From: Martyn White
Sent: 24 June 2019 12:22
To: Planning.Responses
Cc: Anita Gardner
Subject: AB/48/19/PL & AB/49/19/L

AB/48/19/PL & AB/49/19/L

Listed building consent for internal and external alterations to facilitate the change of use of upper floors to a single, four bedroomed residential unit [use class C3a] and ground floor to a commercial unit (use classes A1,A2 & B1a).

**EXISTING AND
PROPOSED CROSS
SECTIONS**

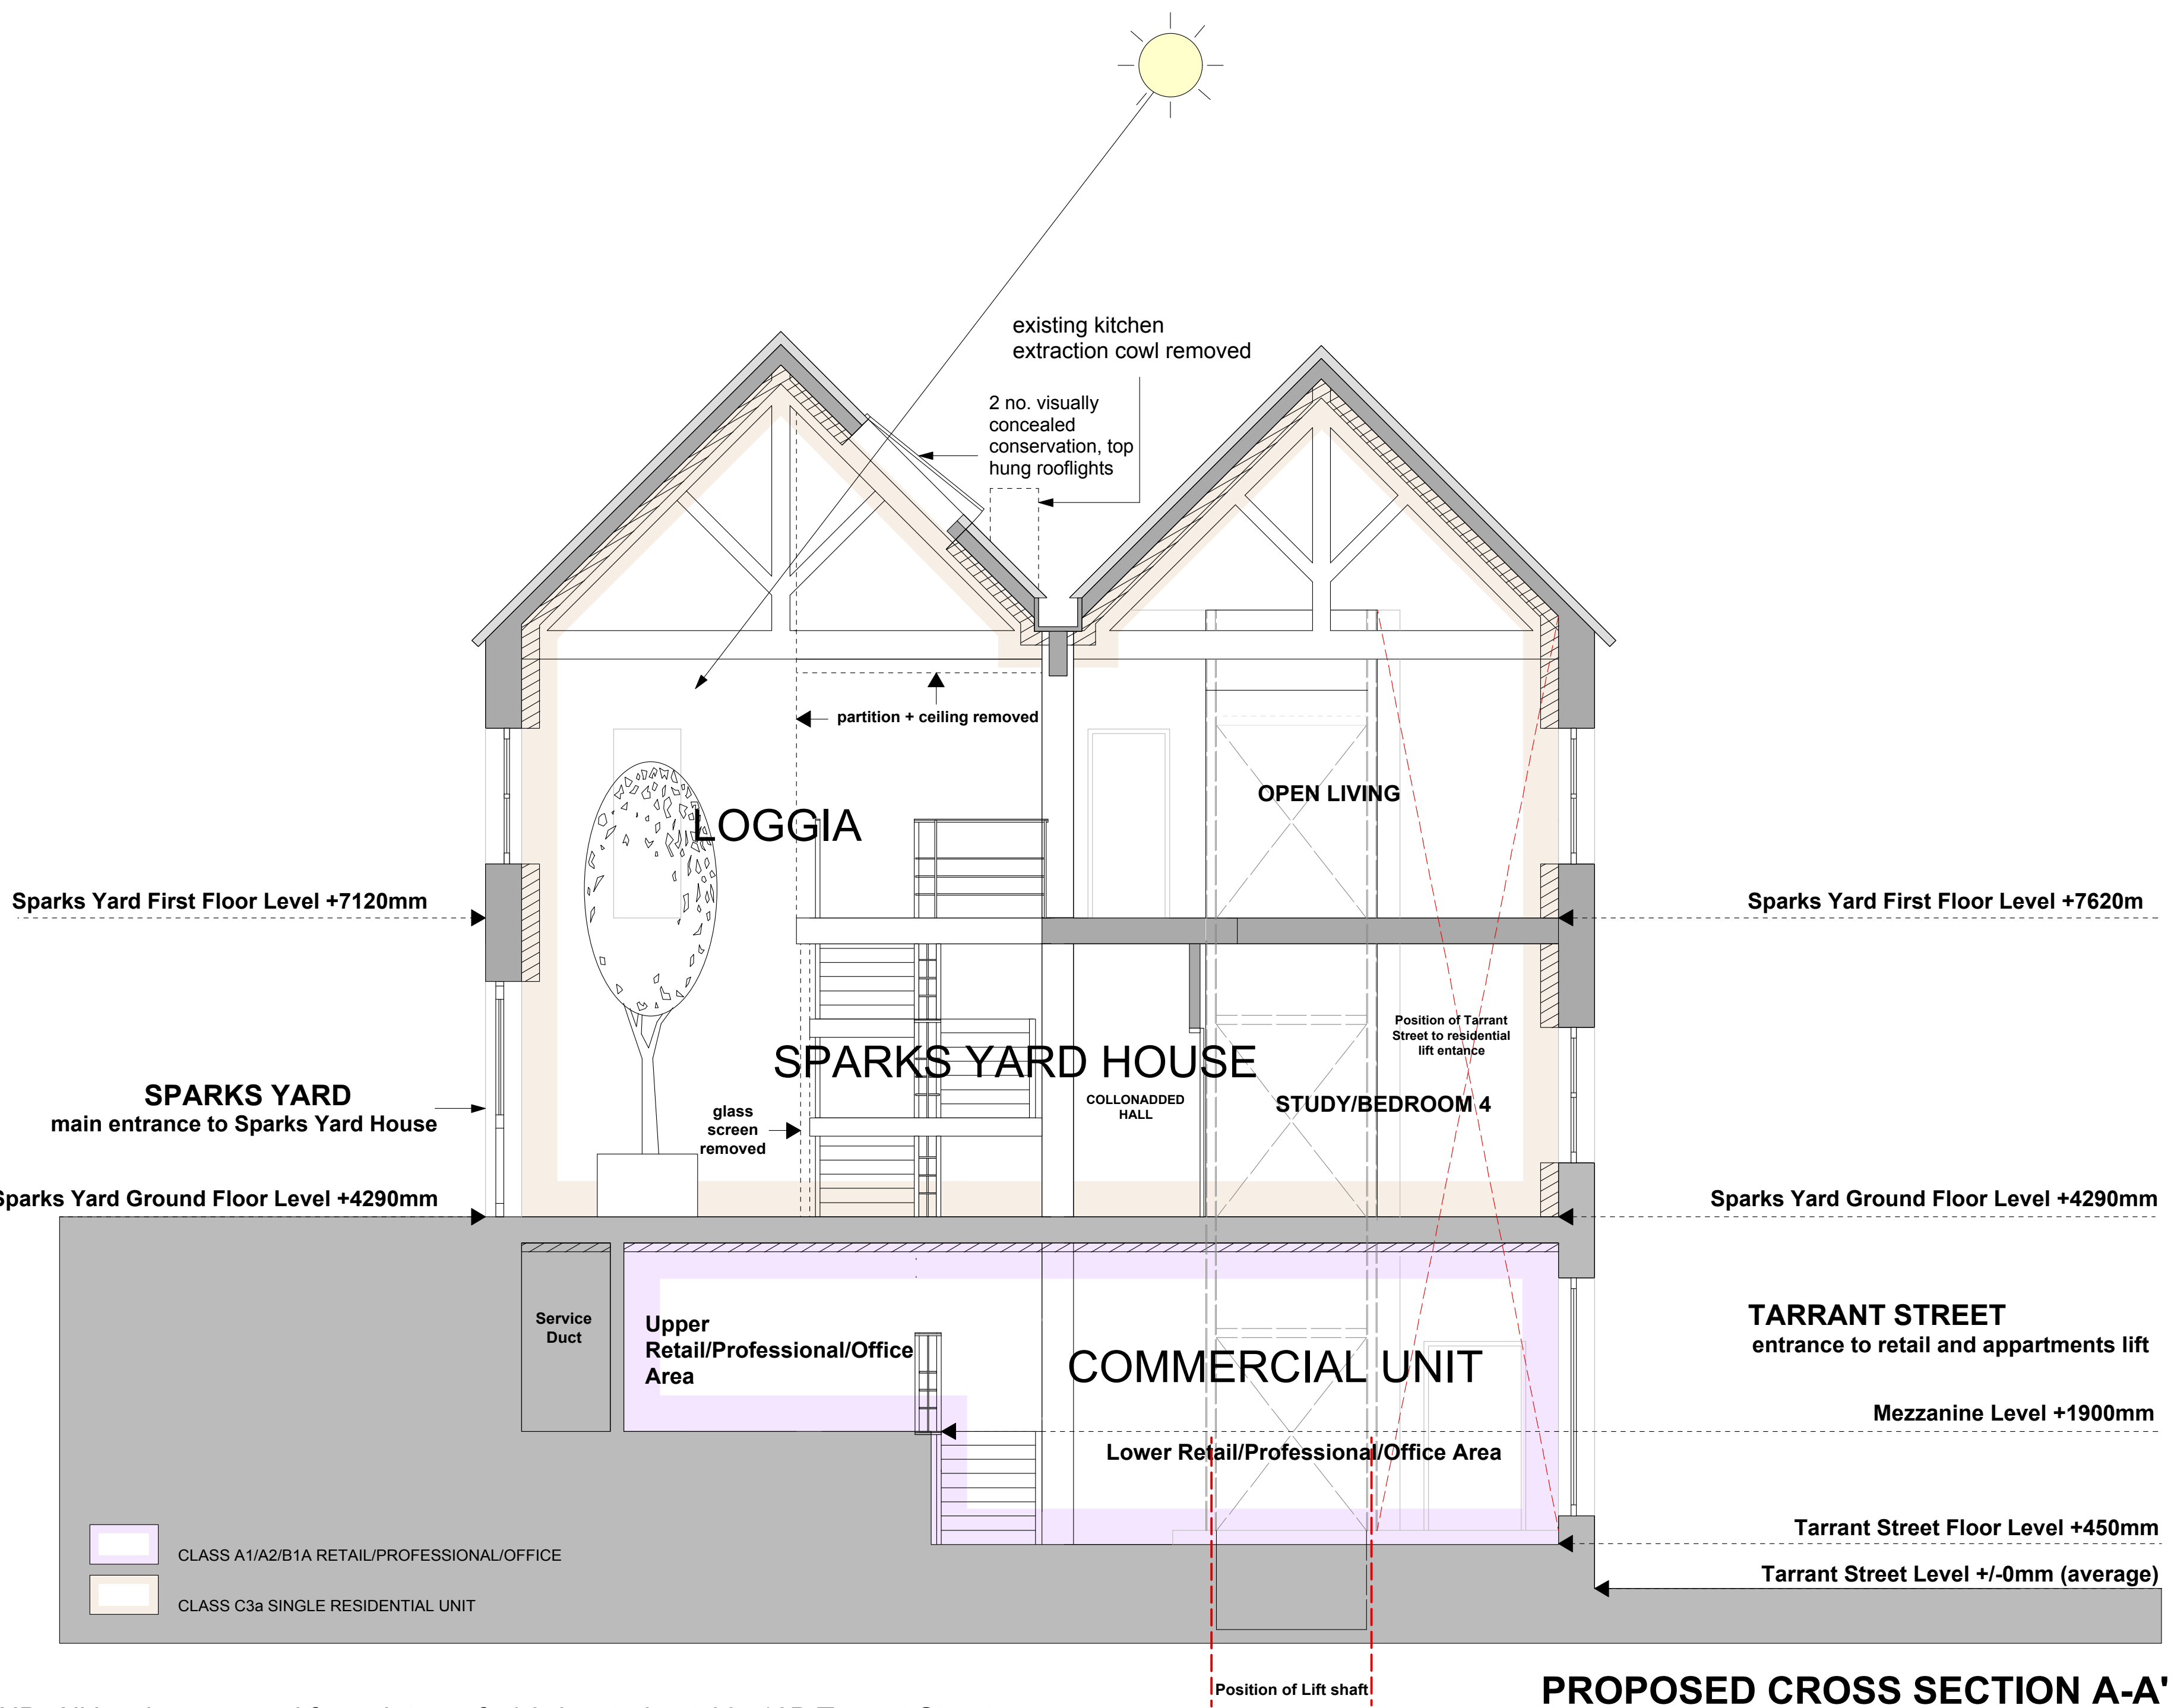
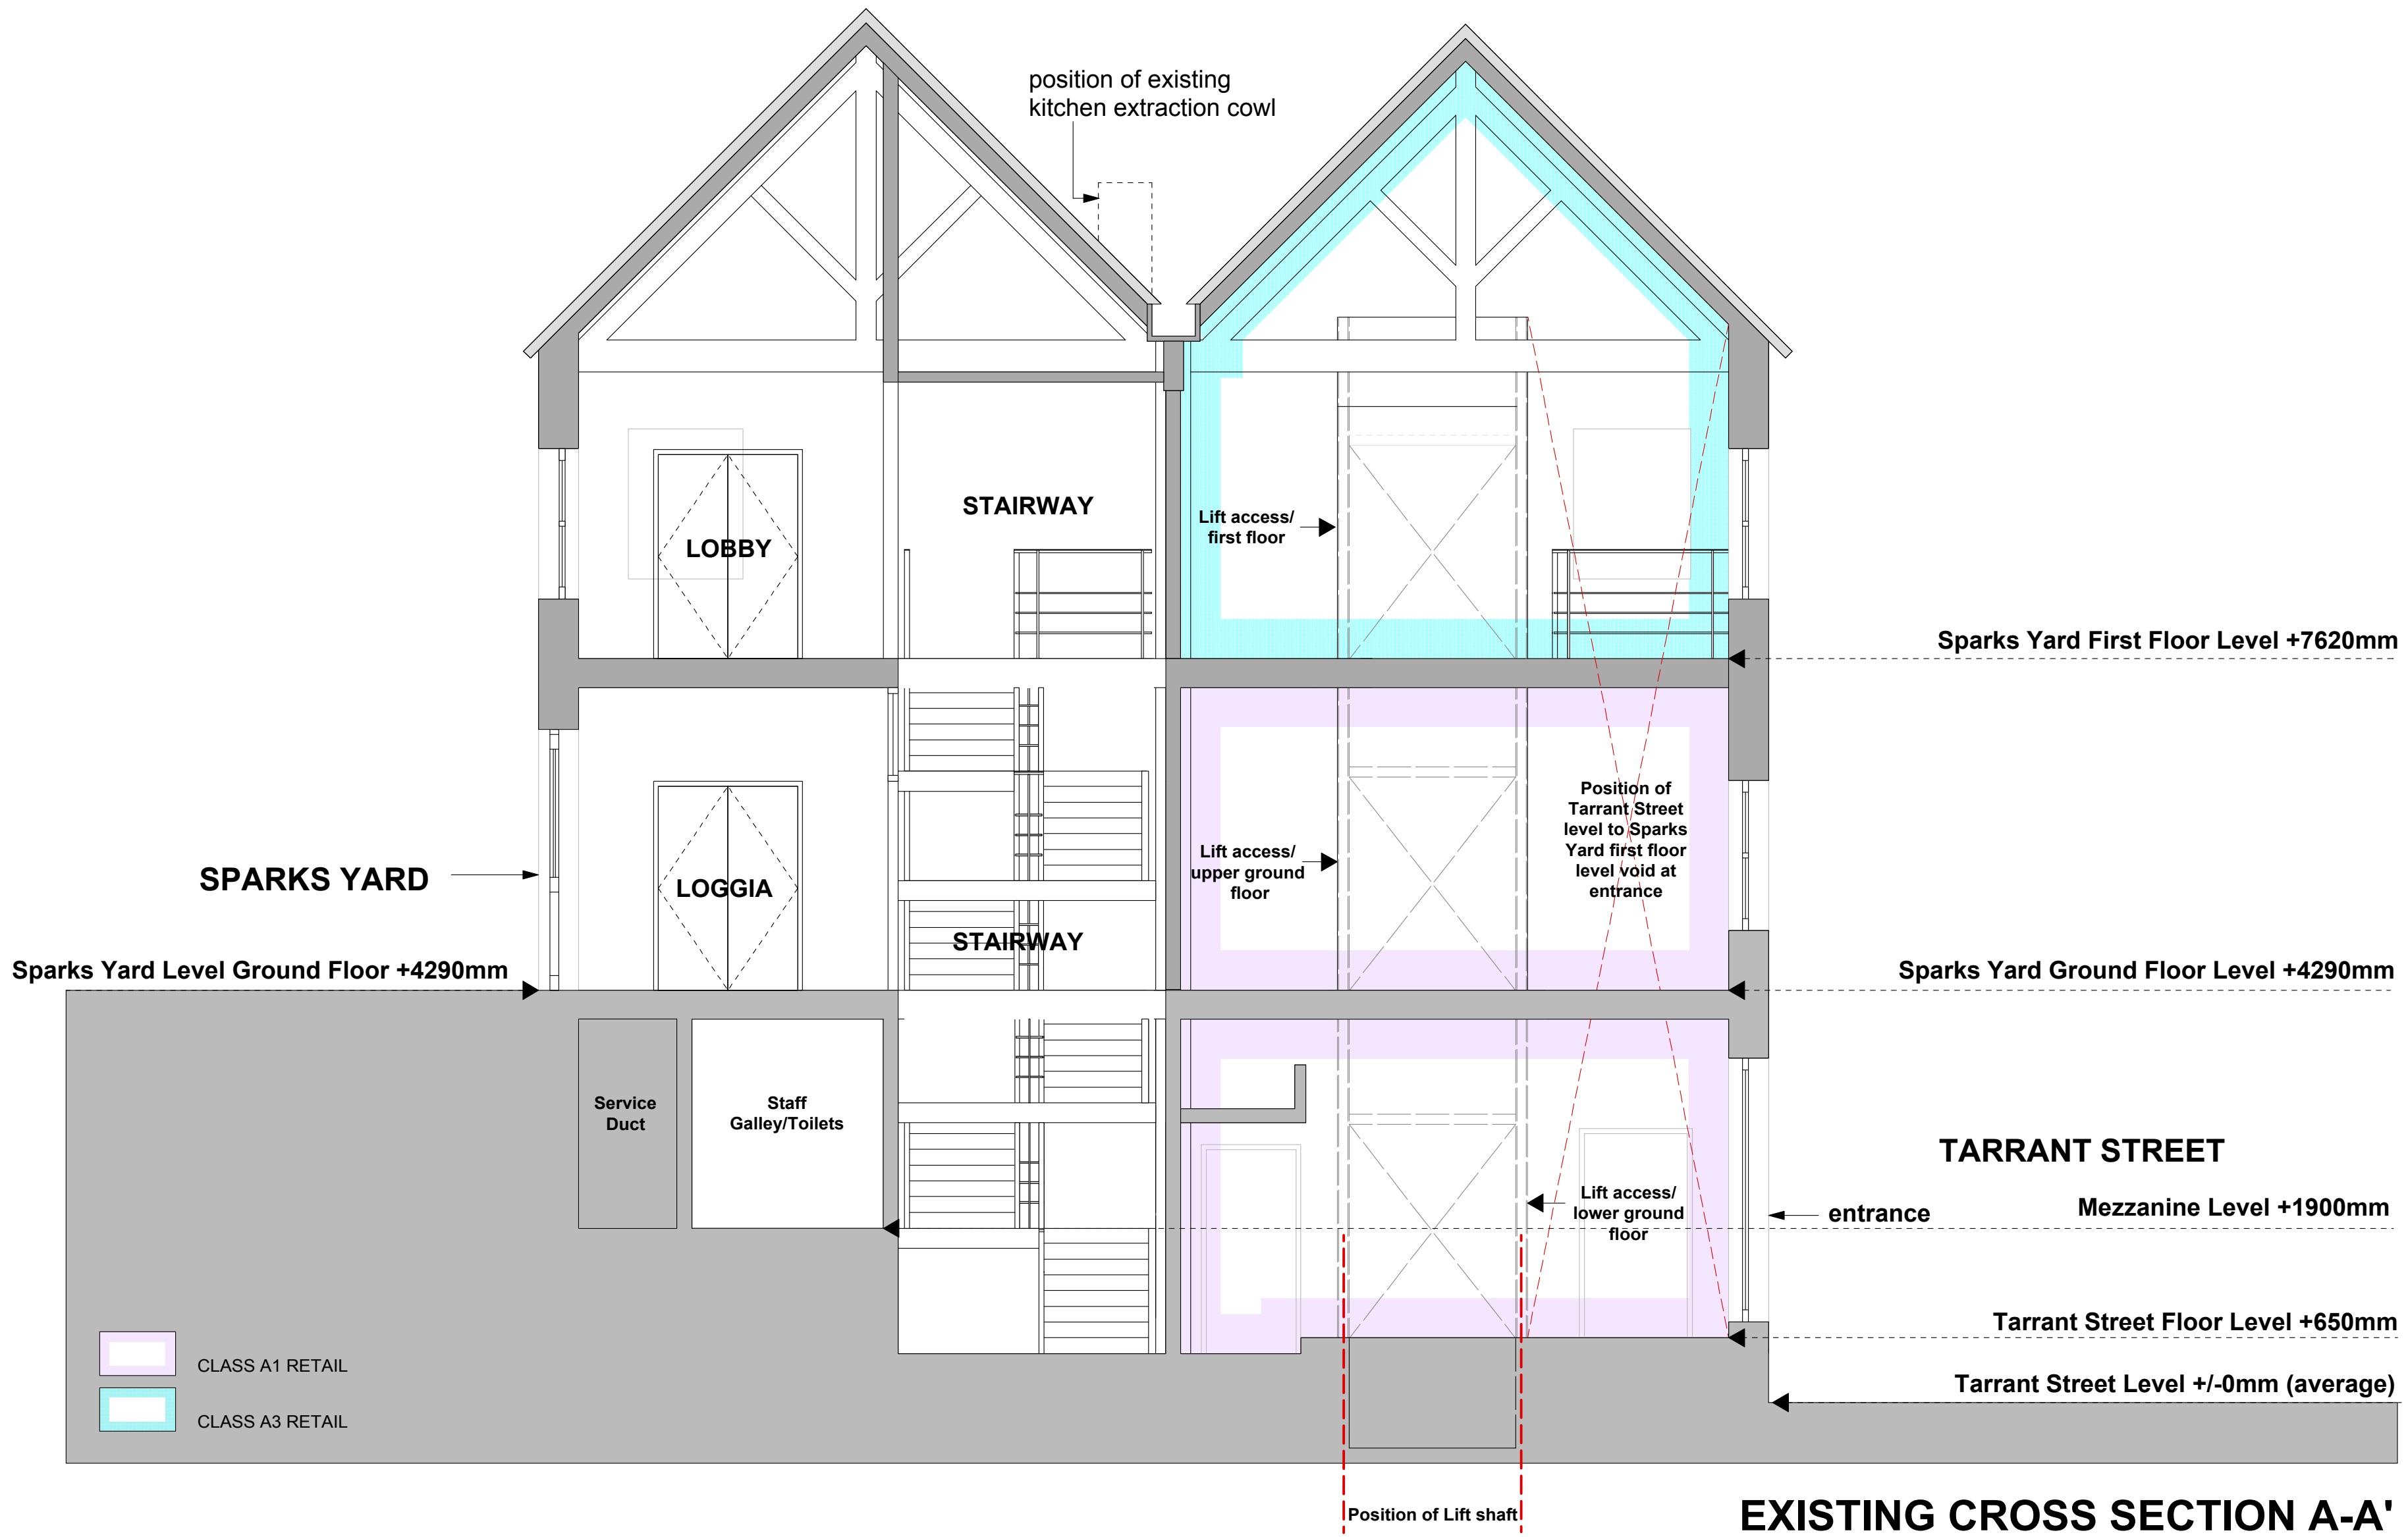
The only concern relates to the proposal to cover internal brick walling with plasterboard. I note that reference is made to the fact that the brick walling will be left exposed if possible. However, covering up a significant amount of the brick work will negatively affect the character of the building. Such an issue should be reconsidered.
